**From:** Farhad Khatibi  
**Sent:** 11 August 2025 12:02  
**To:** Planning ContactCentre  
**Subject:** RE: Attached letter from Kirklees Council regarding application number 2025/91184 at location land off, Bretton Street, Savile Town, Dewsbury, WF12 9BZ

Bridges & Structures Manager  
Structures Section  
Highways and Streetscene  
Kirklees Council

Project No. 2024 Enquiry 51	Project Title proposed sections	Scale 1:100 @A1 size	Date 7/1/2025
Drawn By 104	Reviewed By MC	Scale 1:100 @A1 size	Date 7/1/2025
Drawn No. 104	Reviewed Title	Scale	Revision A

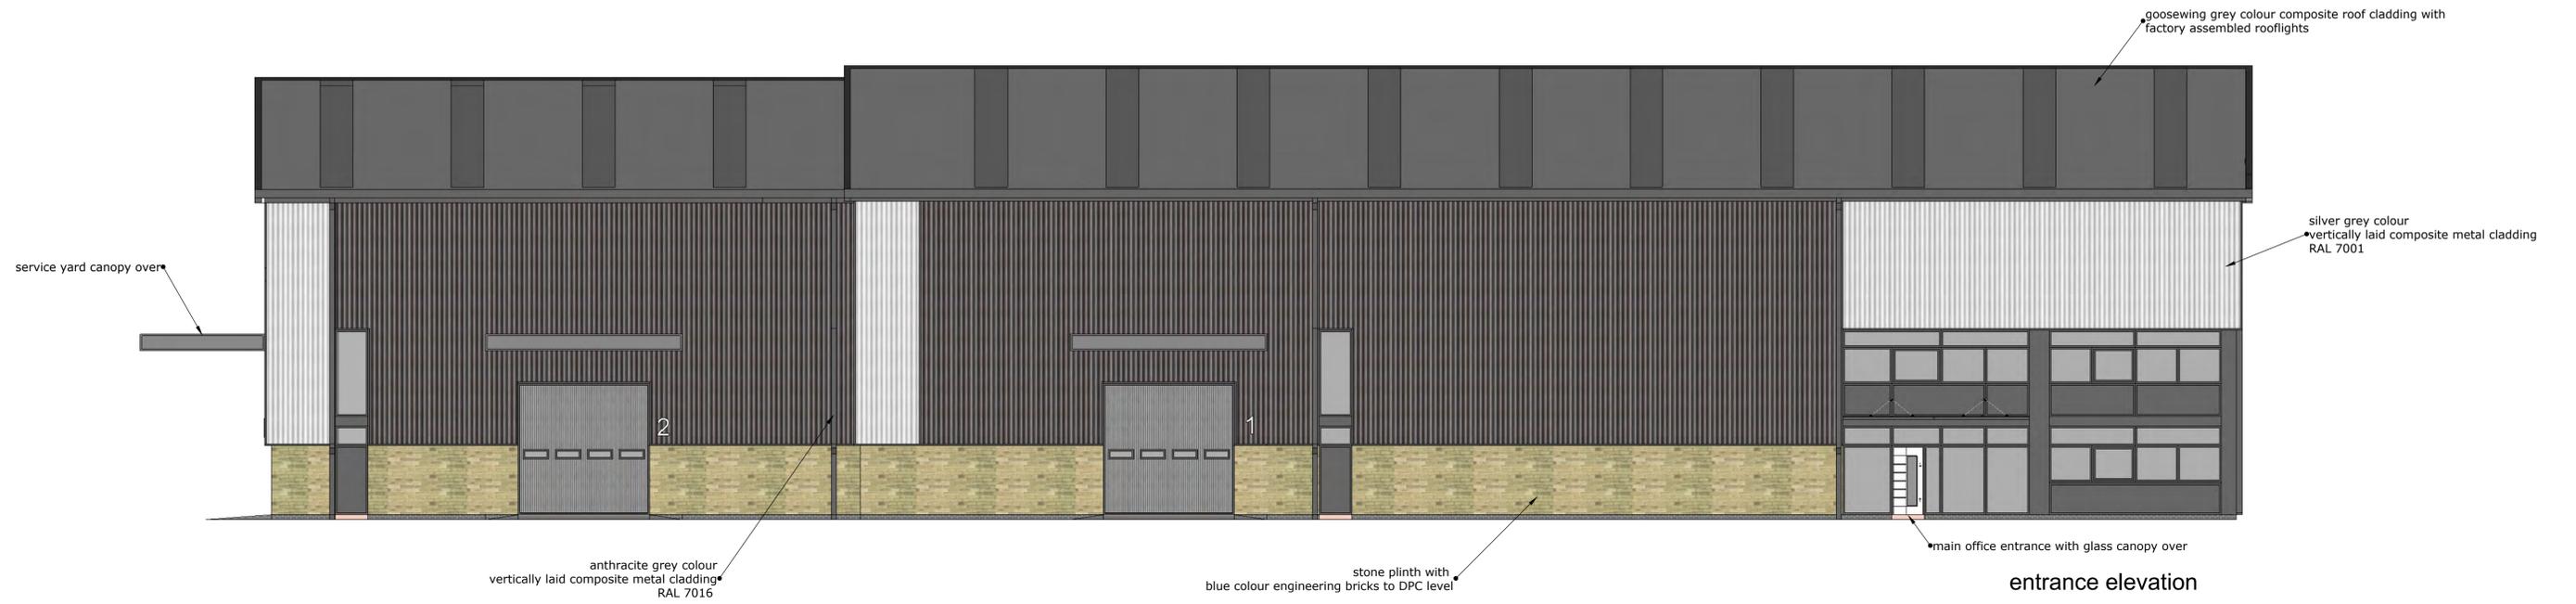
- 1) Before the development commences a scheme detailing the location and cross sectional information together with the proposed design and construction details for all new retaining walls/ building retaining walls adjacent to the existing highway shall be submitted (via submission of an AIP) and approved by the Highways Structures Section in writing. The approved scheme shall be implemented prior to the commencement of the proposed development and thereafter retained during the life of the development.
